From: Simon Davis
Sent: 16 September 2025 16:18
To: Planning Scanning
Subject: FW: Y/57/25/PL Sunnymead

From: cheryl wellstead [REDACTED]
Sent: 16 September 2025 16:05
To: Simon Davis <Simon.Davis@arun.gov.uk>
Subject: Y/57/25/PL Sunnymead

STREET SCENE - Viewed from North End Road [1:200]

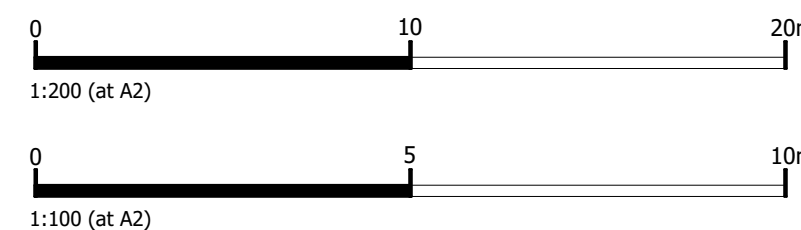
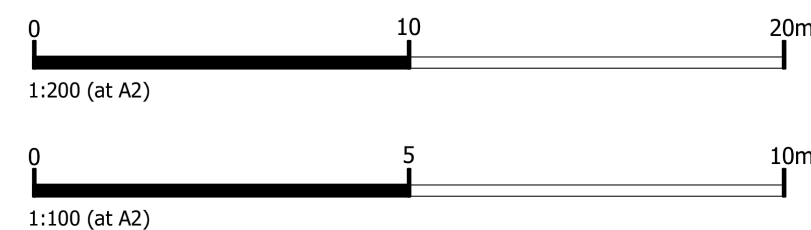
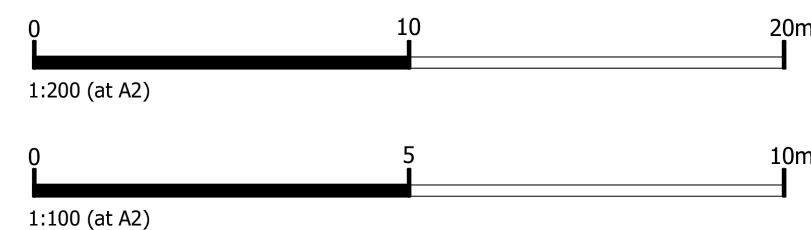
YPC would expect substantial landscaping improvements made to the site as recommended by the applicant's own ecology report. The current proposal is wholly inadequate and fails to restore and indeed enhance the biodiversity of the site that was so cynically removed. For this reason alone, the application should be refused. YPC has reservations regarding the boundary treatment of the site. The urban form and scale of the fence is harmful to the character and appearance of the locality and is overtly dominant in the countryside and the street scene of North End Road. As such the fence causes detrimental harm to the character, appearance and visual amenity of the land. It should be reduced in height and soften with the introduction of a native deciduous hedgerow if progressed.

Significant landscaping enhancements are proposed, including tree and native hedgerow planting together with a number of ecological enhancements. In regards to the boundary treatment to the front of the site, the applicant is happy to look at an alternative such as native hedgerow with a lower fence.
